HINCKLEY NATIONAL RAIL FREIGHT INTERCHANGE

Project reference TR050007

Applicant's Response to Deadline 4 Submissions [part 2 - HBBC]

Applicant's Response to HBBC Deadline 4 Submission - Response to Additional Deadline 3 Submissions

Written Statement of Oral Case ISH2 [Appendix I - Accessibility Plans for Burbage Common Road]

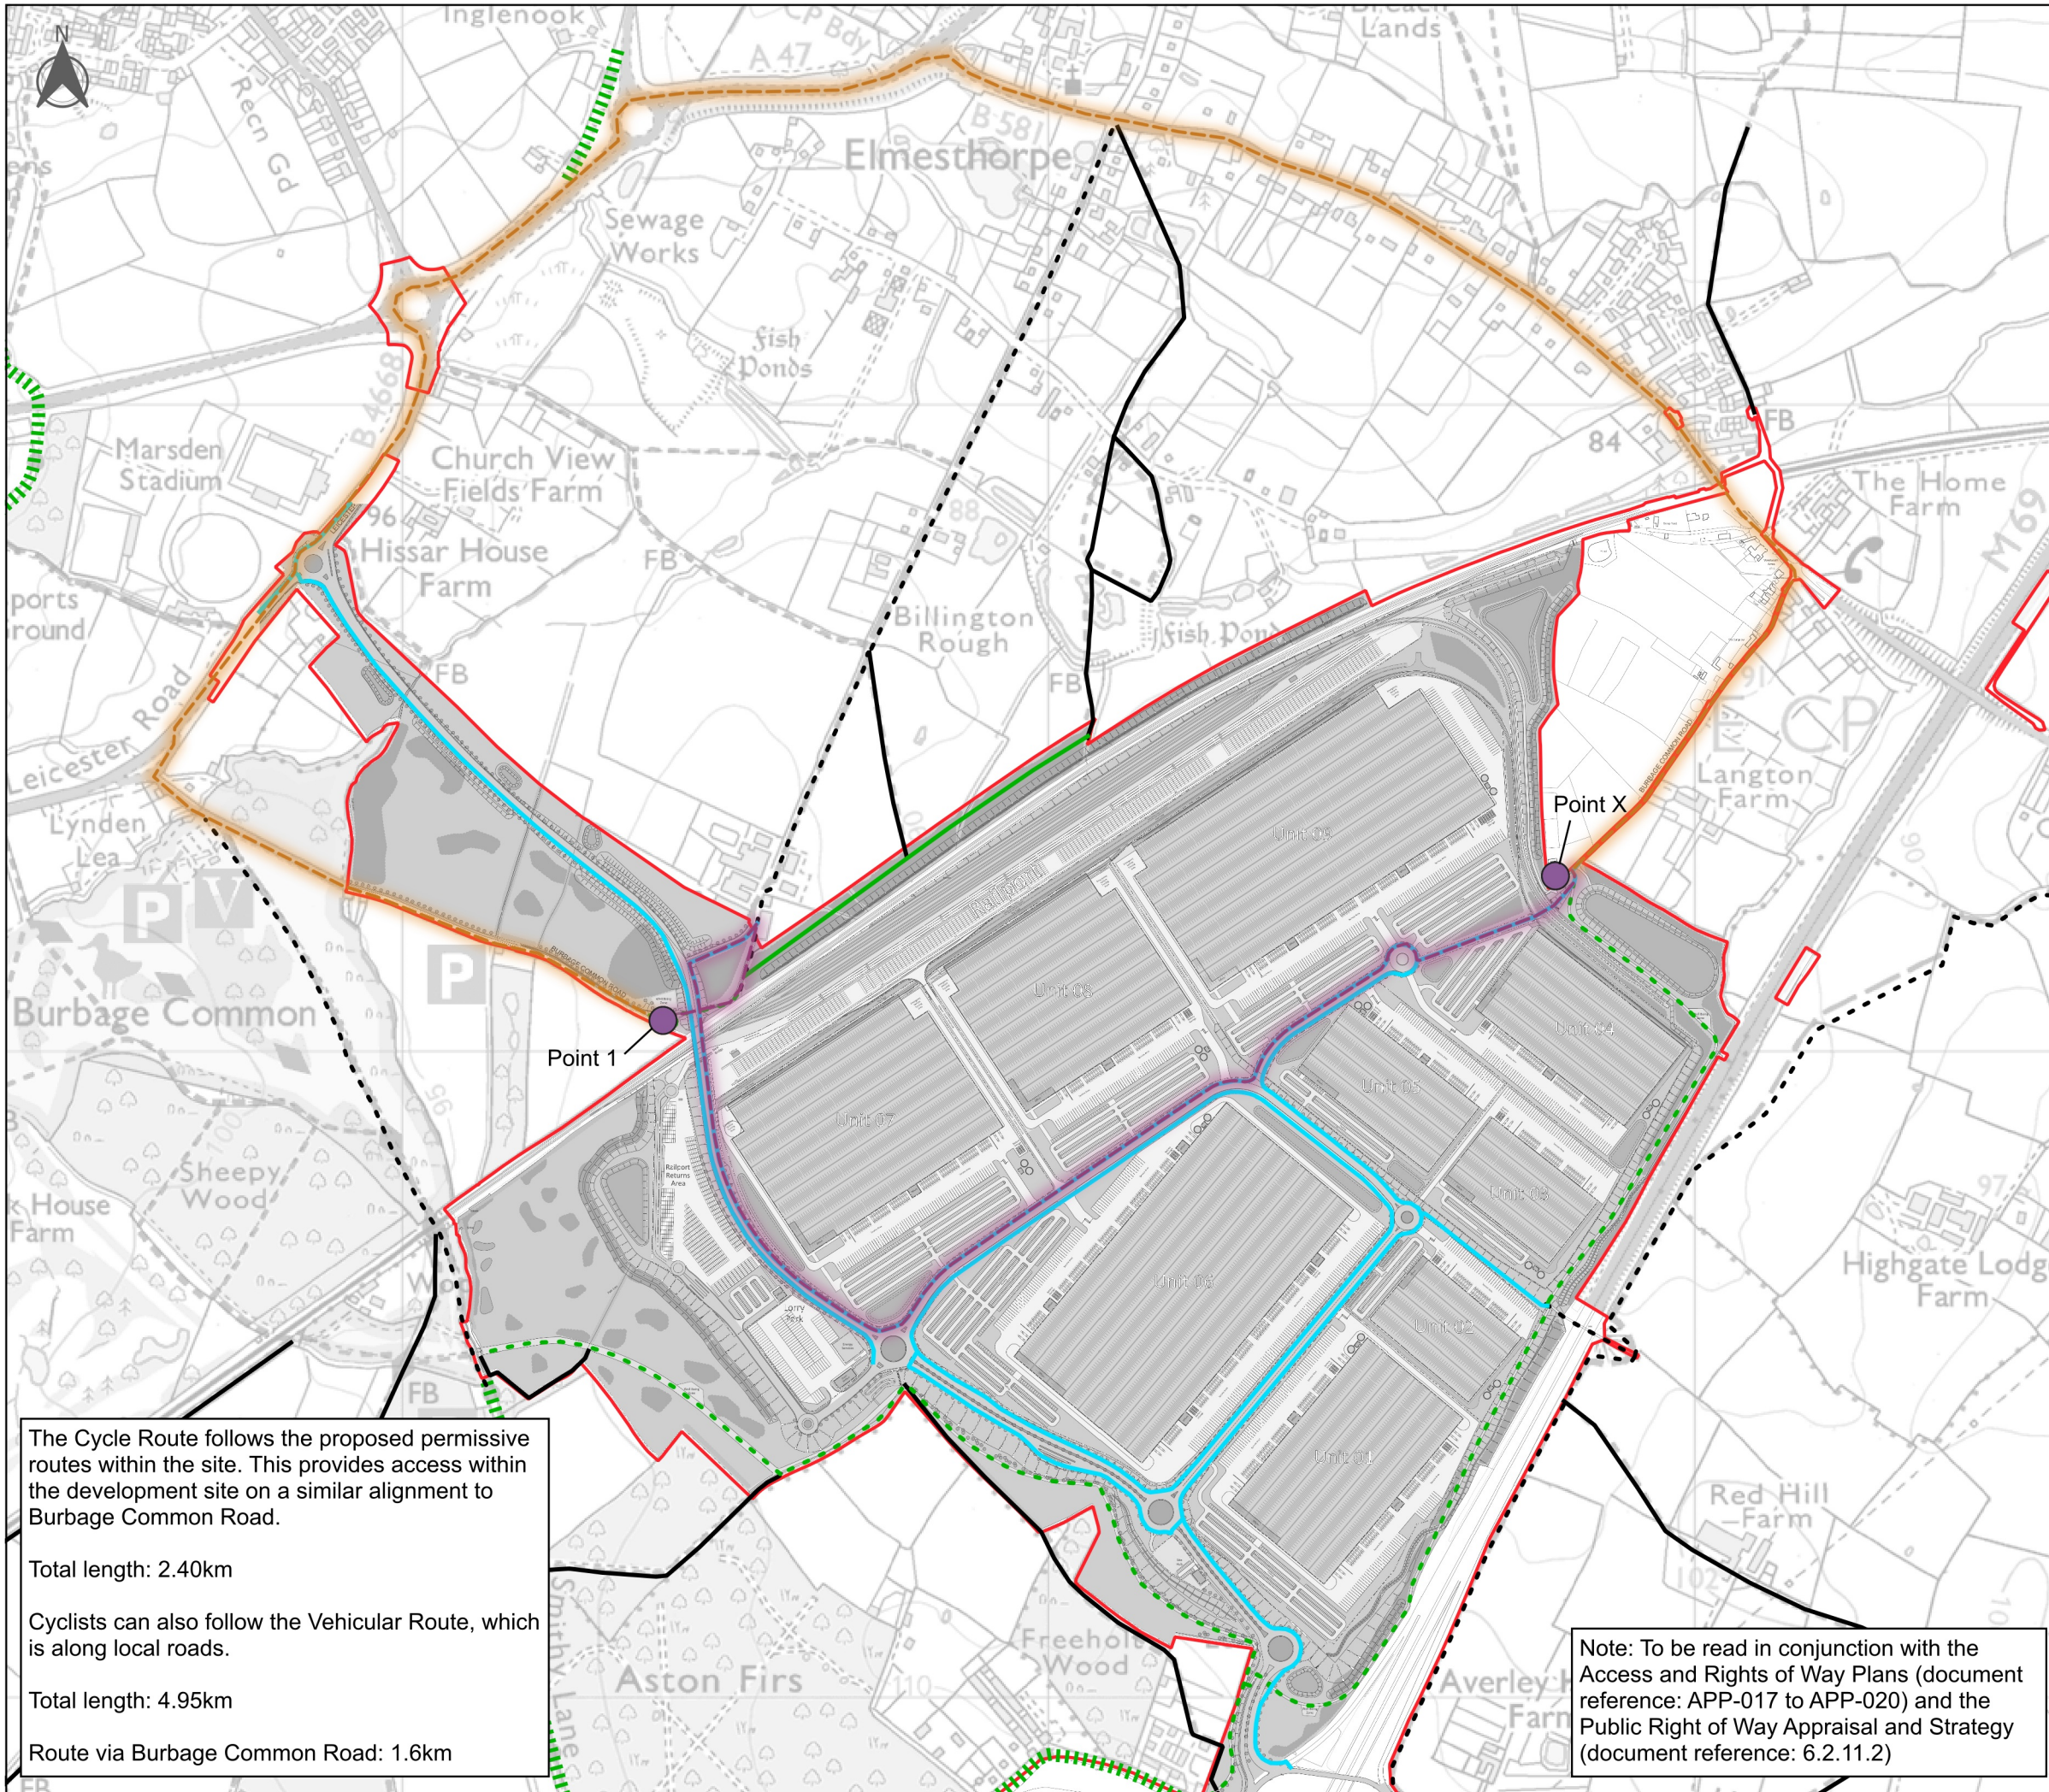
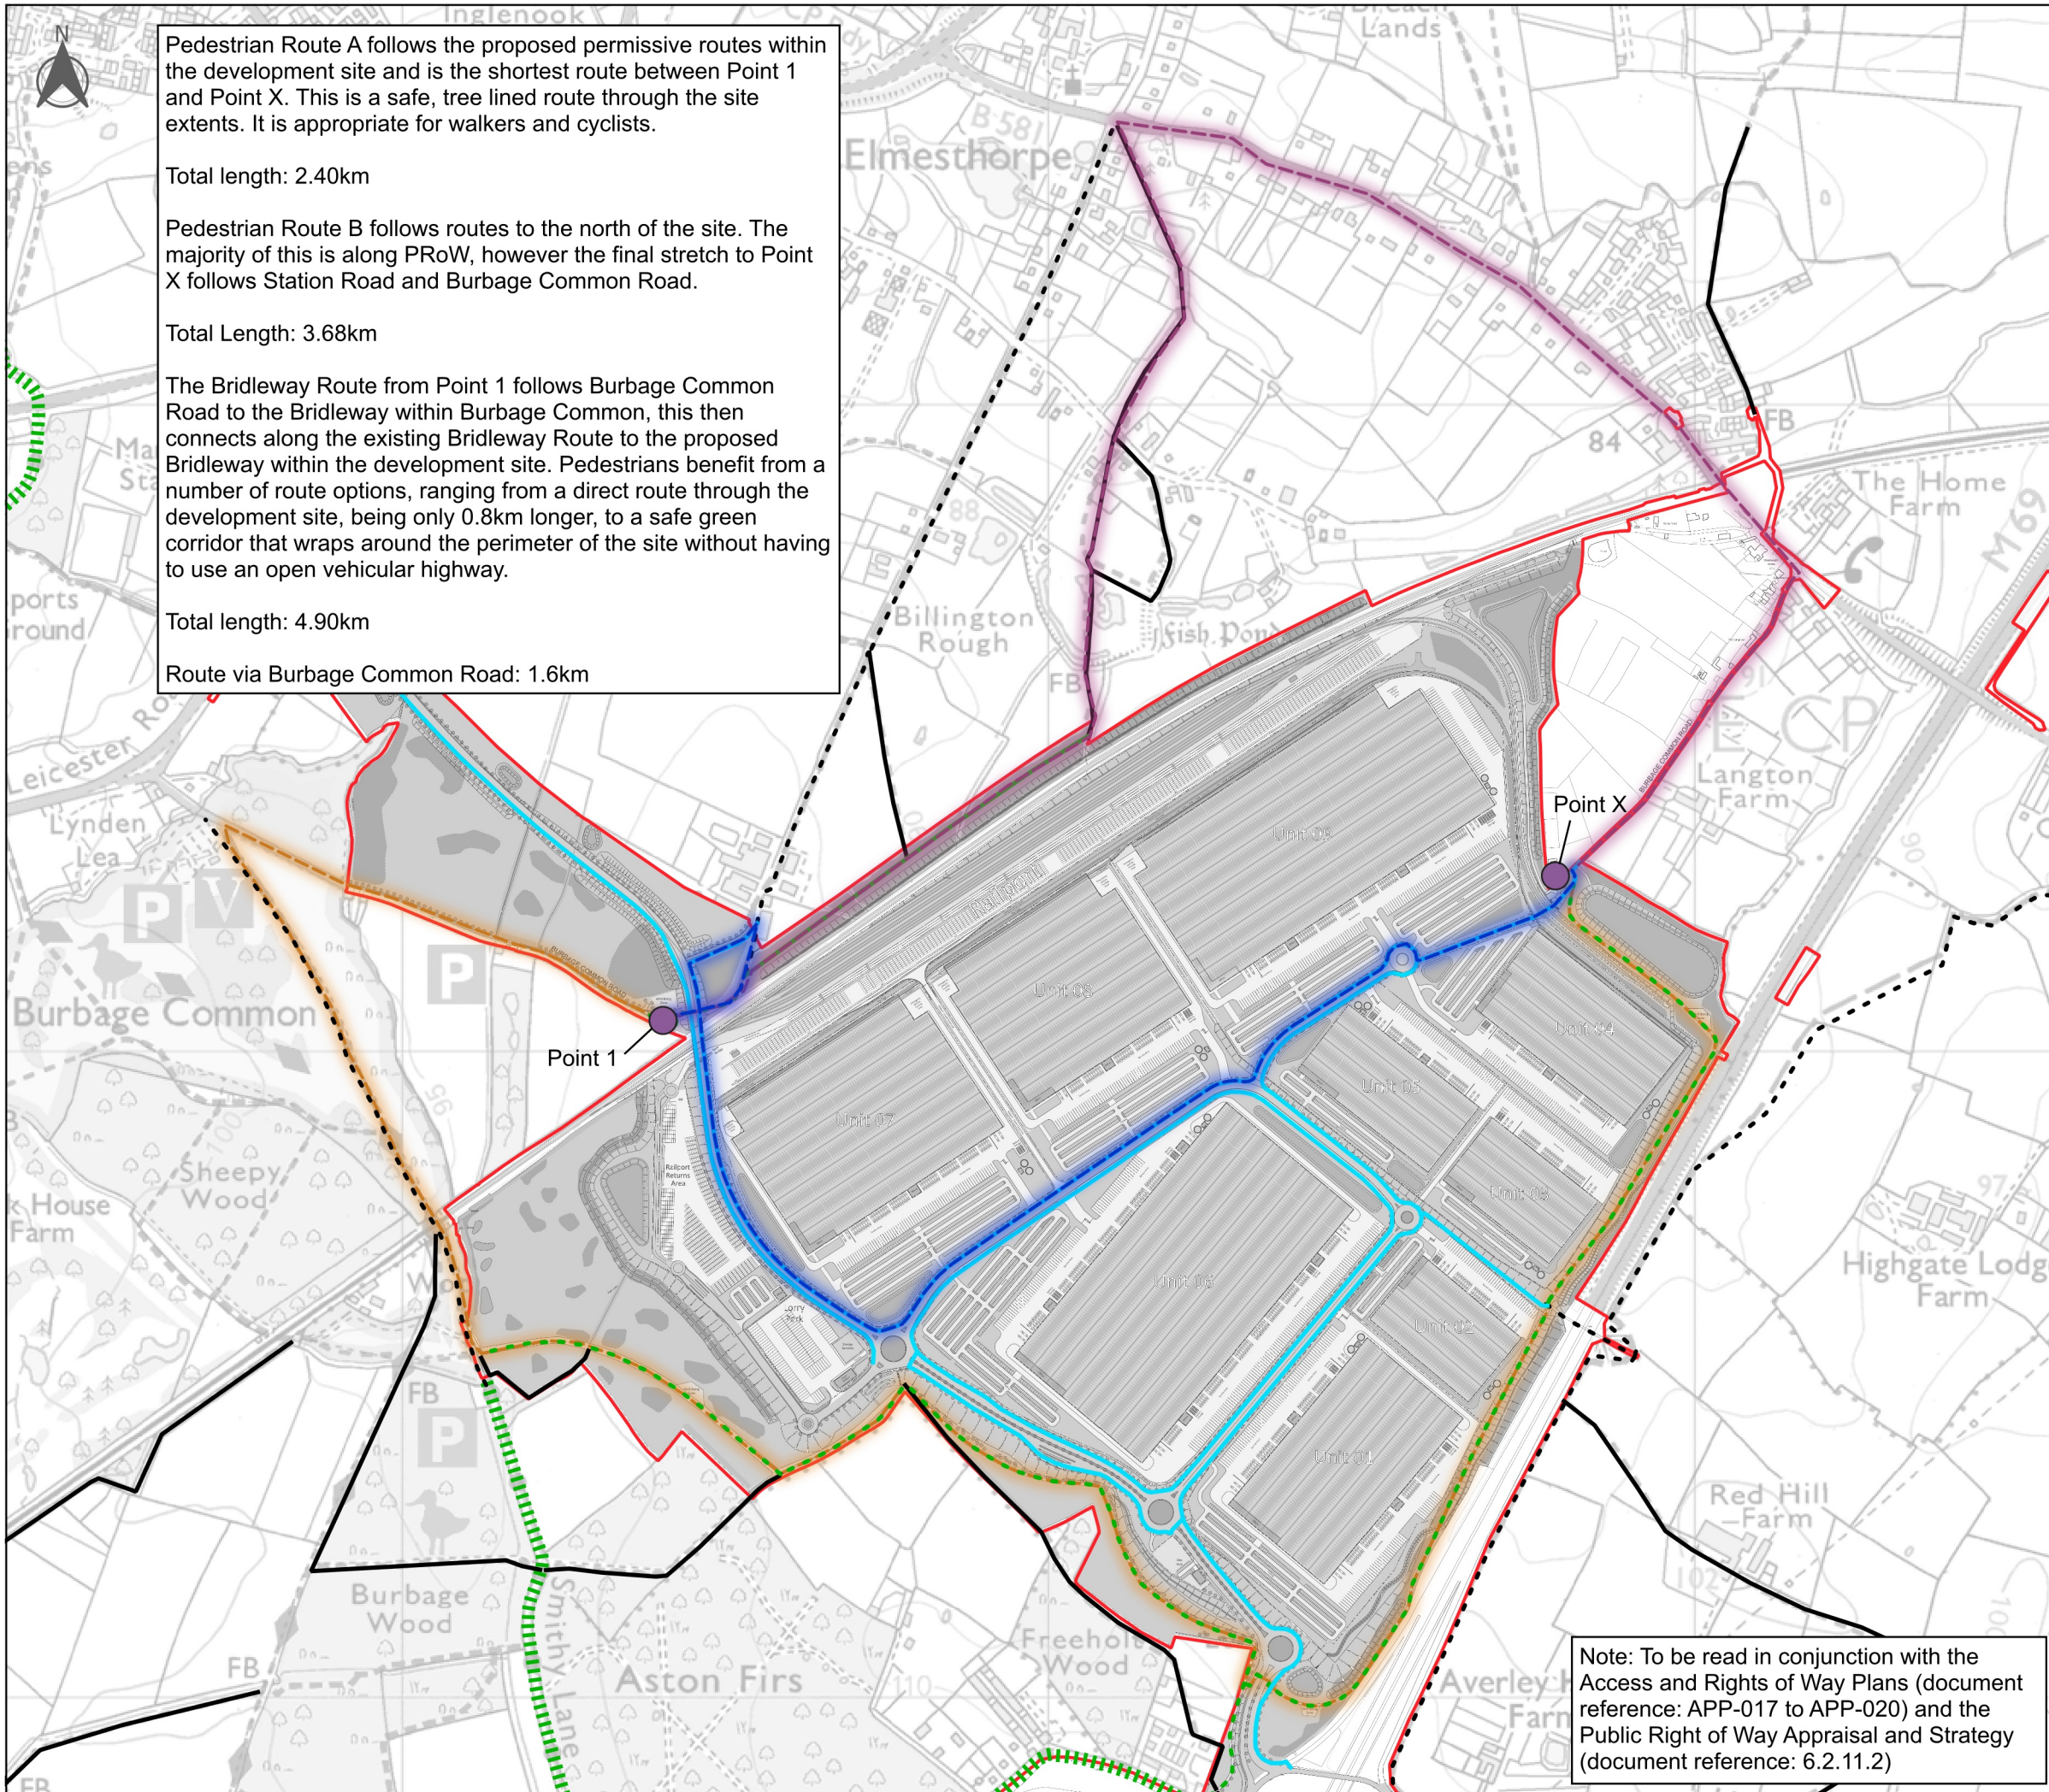
8	REP3 – 054 – Accessibility	The accessibility plans for walking and cycling appear incorrect and thus confusing. For example	Figure 11.14A has been updated for Deadline 5 to clarify the position in relation to permissive paths and

No	ExQ Ref	Hinckley & Bosworth Council Response	Applicant's Response
	Plans for Burbage Common Road	they show a 'proposed permissive path' for walkers and cyclists along the A47 – but the Council would expect these to be part of the publicly adopted highway and thus, not permissive paths. The council has expressed concern at details of these routes including the need to cross the link road in path continuity and how safe and what quality the permissive paths will be across the site as well as crossing facilities - these concerns remain.	adopted paths. A plan showing the footpath / cycleway A47 link road design including crossing points is submitted as Written Statement of Oral Case ISH6 (Appendix C – Plan for A47 link road footway / cycleway design (document reference 18.15.3).
	REP3 – 018 – Framework Travel Plan		Written Statement of Oral Case ISH6 [Appendix C - Plan for A47 link road footway/cycleway design]
